April 9, 2024

RE: 12th Street Road Diet (CPN 718780)
Preliminary Drainage Report
Engineer's Stamp Date: No Date
Hydrology File: H13D120

Based upon the information provided in your submittal received 03/12/2024, the Final Drainage Report **is not** approved for Work Order. The following comments need to be addressed for approval of the above referenced project:

Figure 3

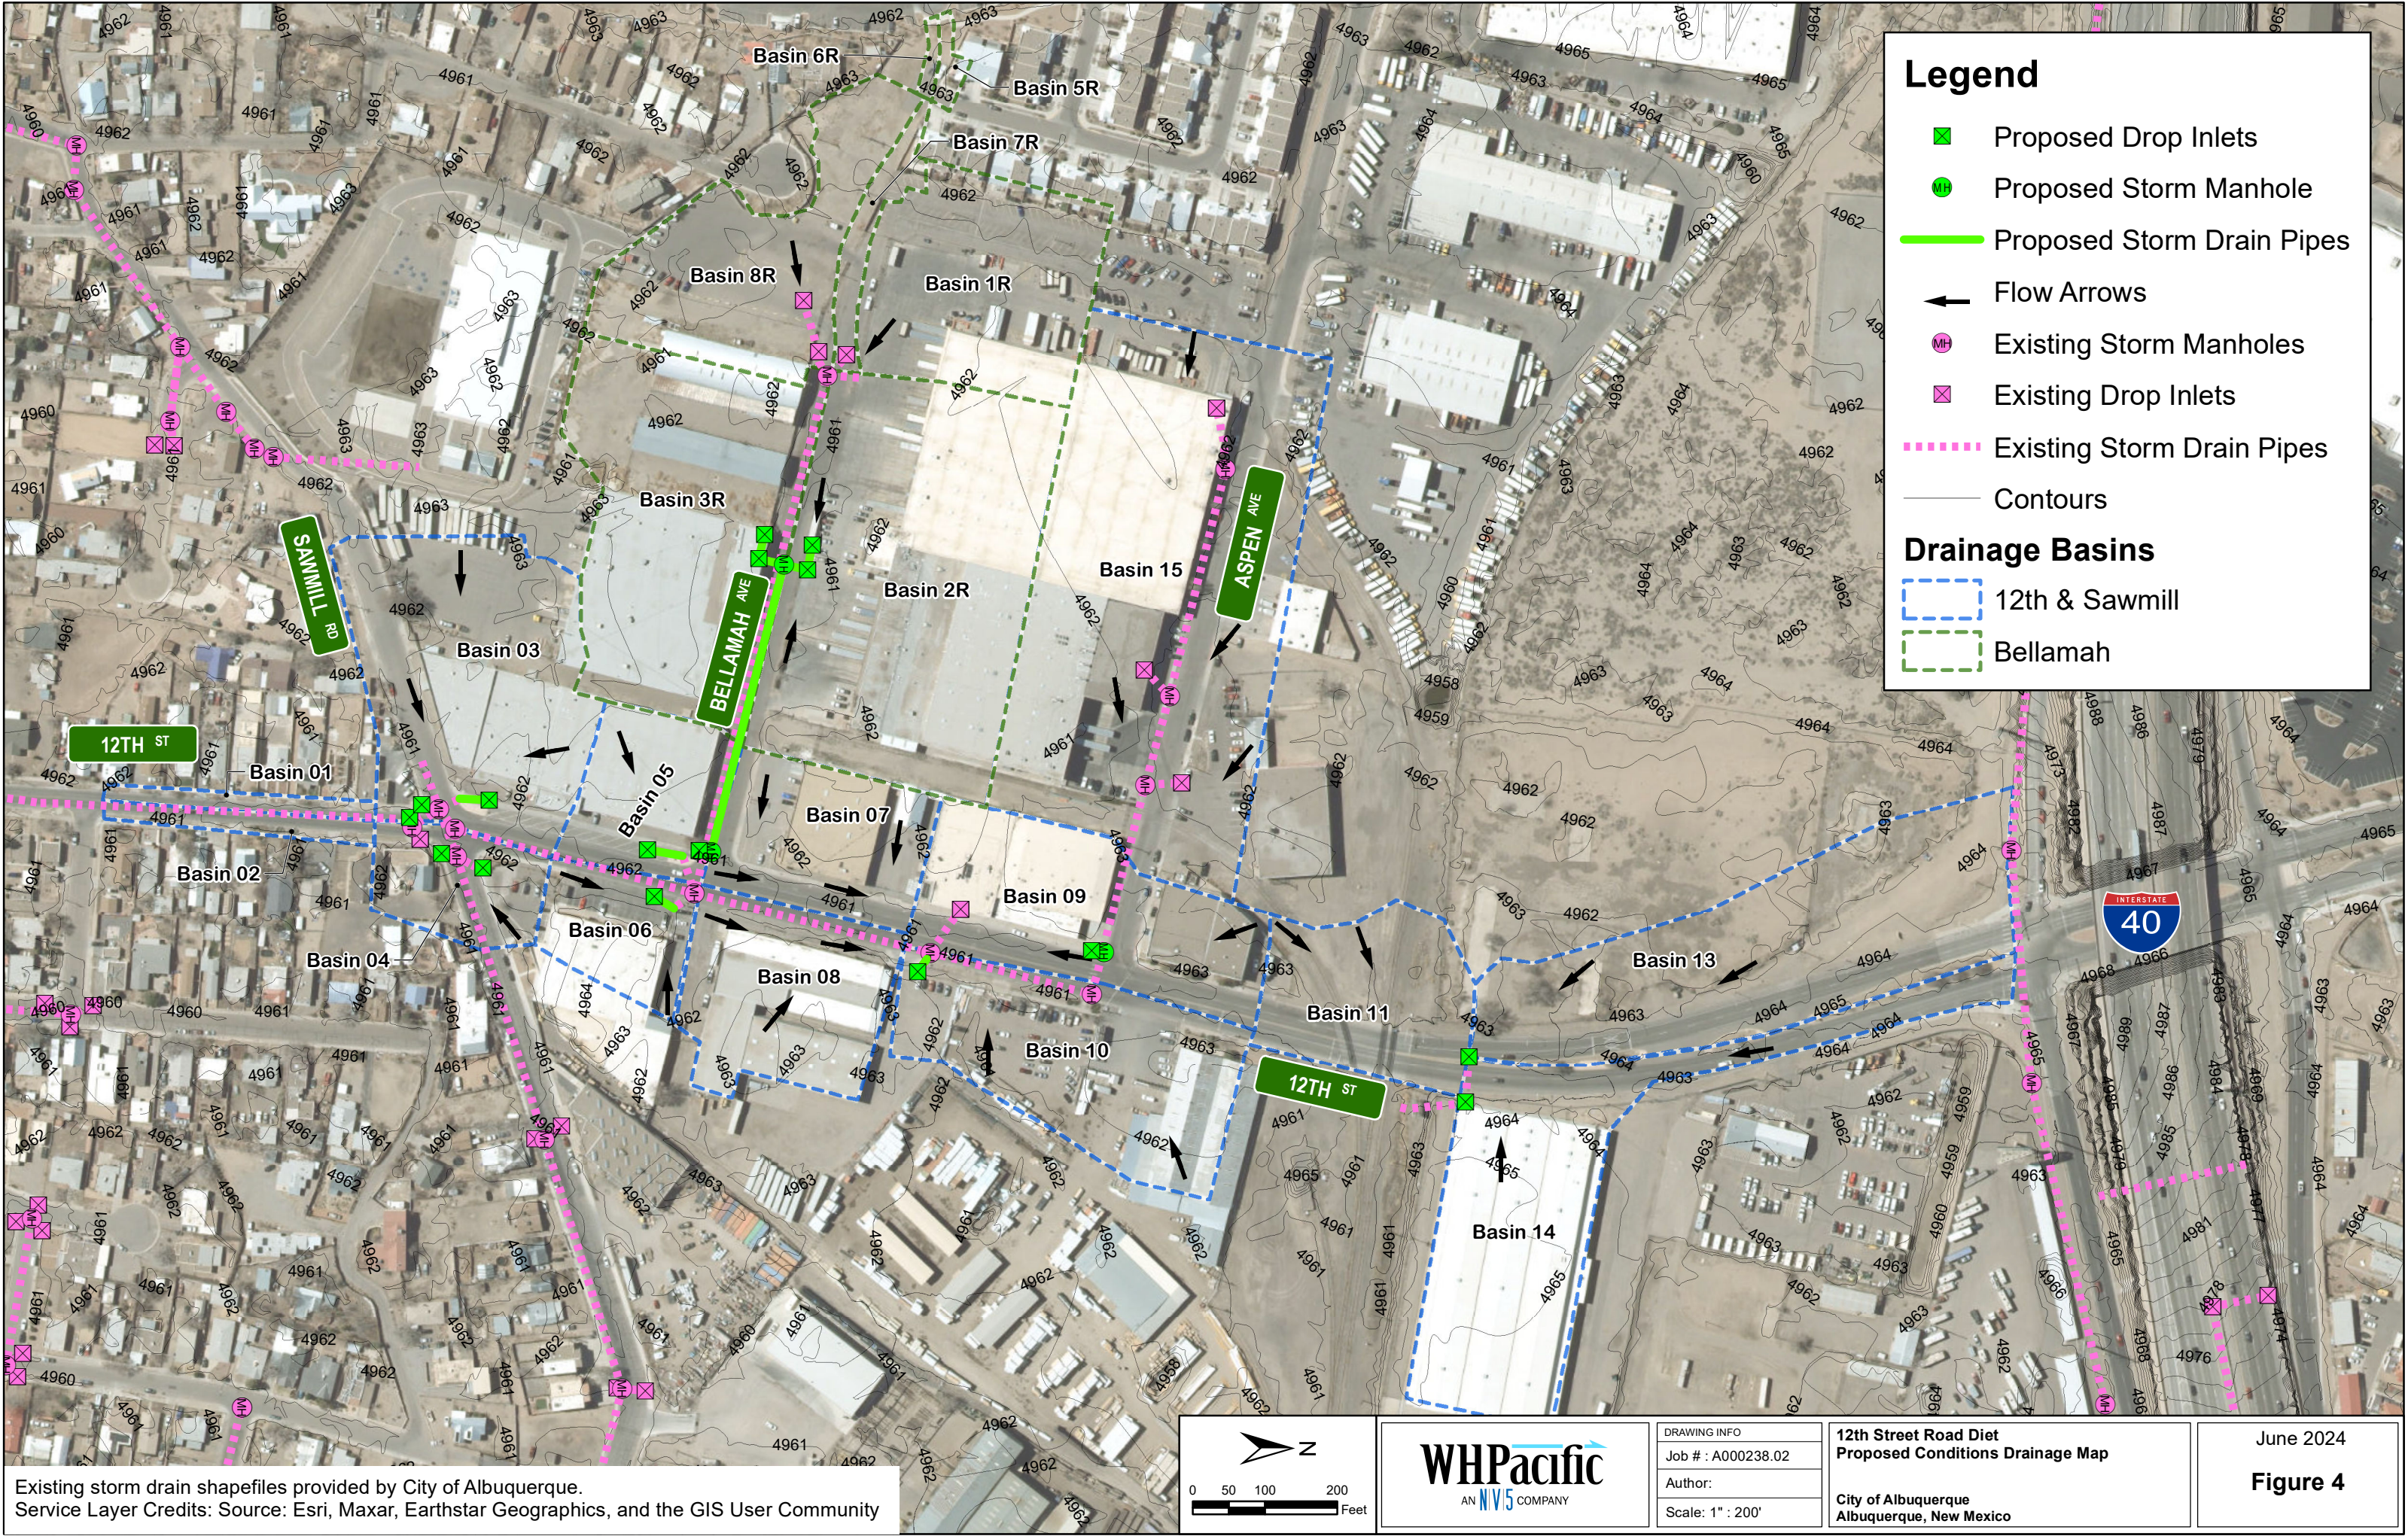
1. Please provide an engineer's stamp with a signature and date.
2. It appears that the drainage area for Bellamah Ave is missing in both the existing conditions and proposed conditions drainage maps.
